GOVERNMENT ARCHITECT NEW SOUTH WALES

PROJECT: Northside Clinic Wentworthville
RE: State Design Review Panel (SDRP) – 24 November 2021
(Second Review)

Thank you for the opportunity to review the above project a second time. Please find below a summary of advice and recommendations arising from the design review session held on 24 November 2021.

Drawing #: DA3000 indicated Rev: 7

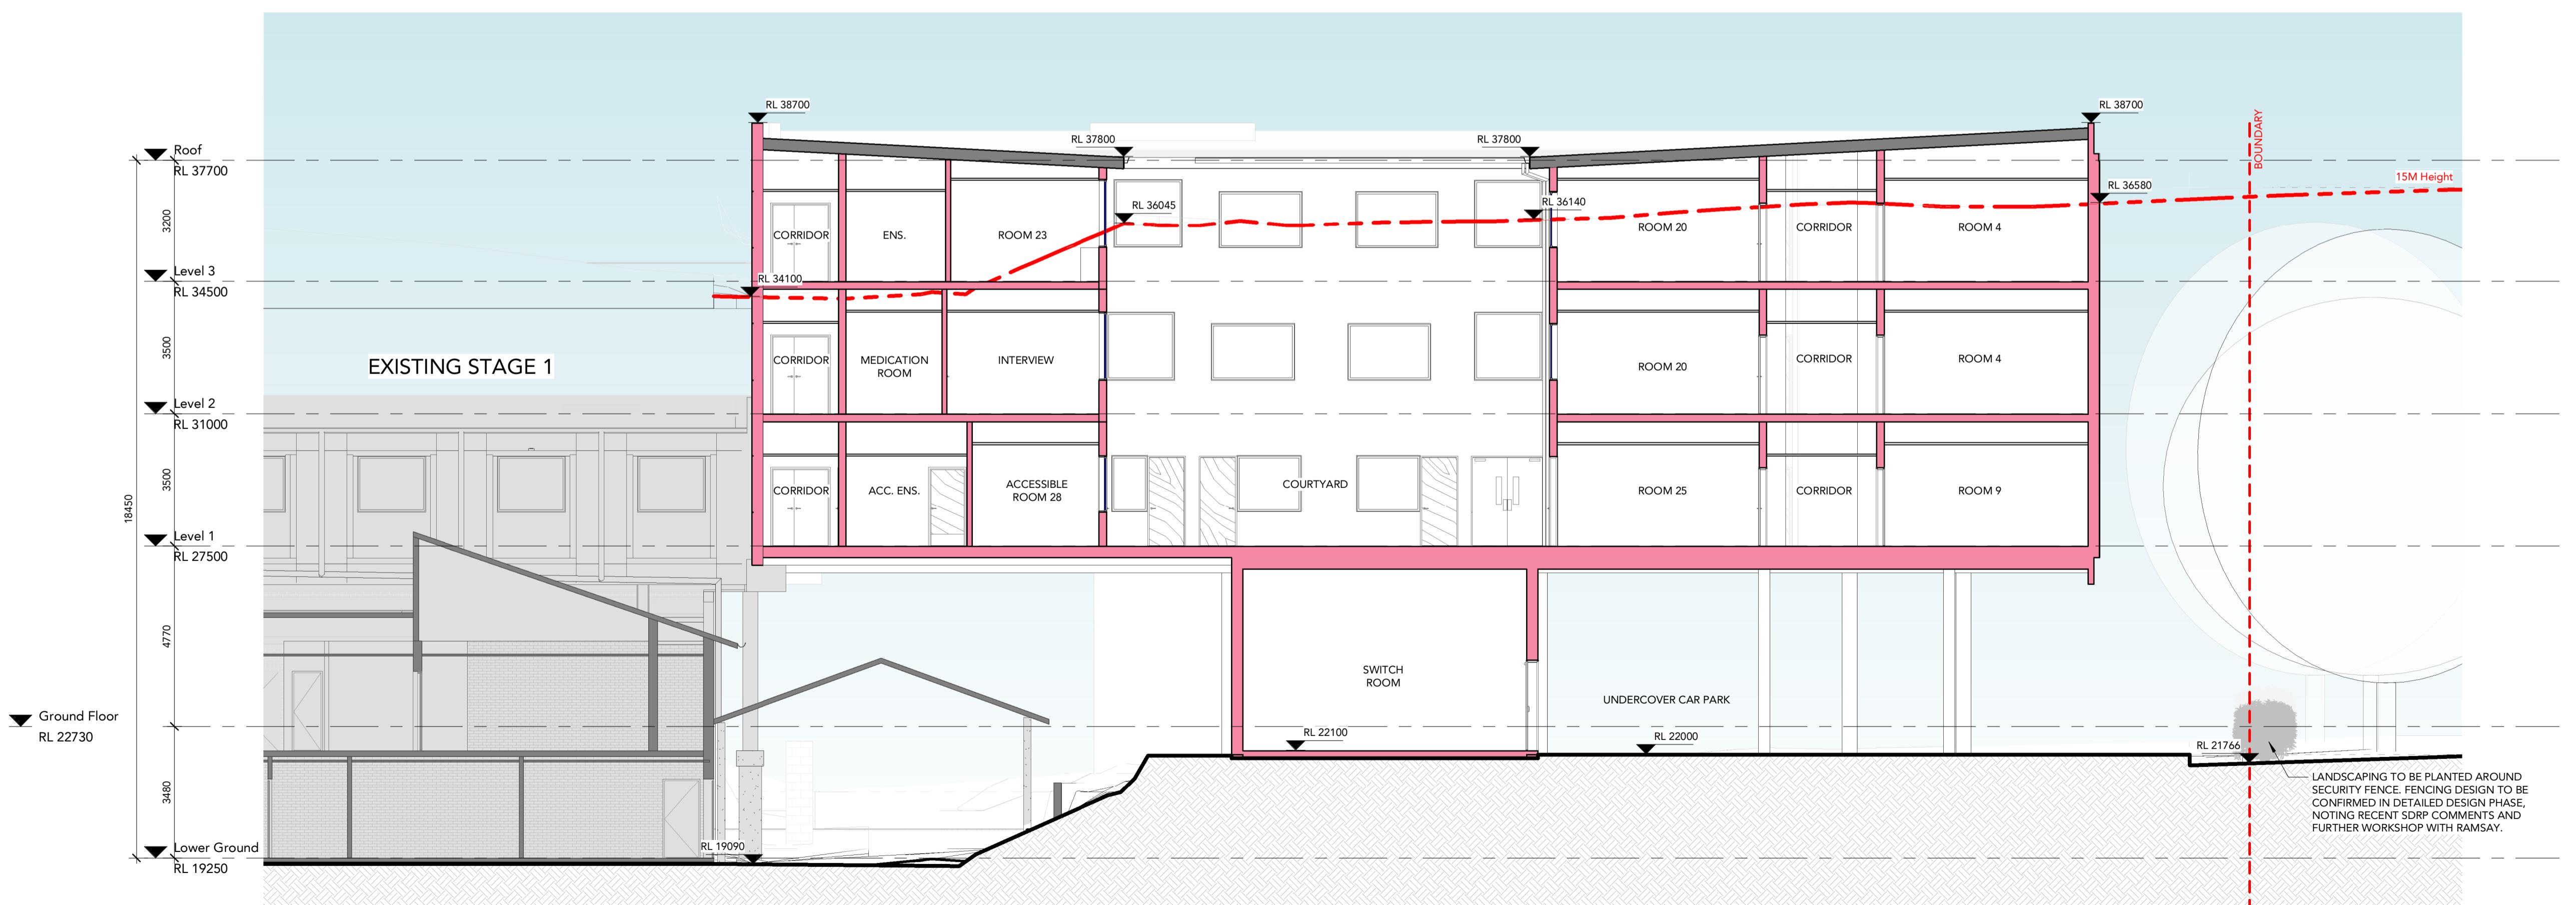
8. Explore how to reduce the building height by removing car parking at the stage 2 ground level and introducing ramps to mitigate the level change between stages 1 and 2.

9. The building height should be reduced to below 15m to mitigate overshadowing to the park during winter.
10. Place active rooms on the ground level to articulate the street and park entrance path in a friendly manner.
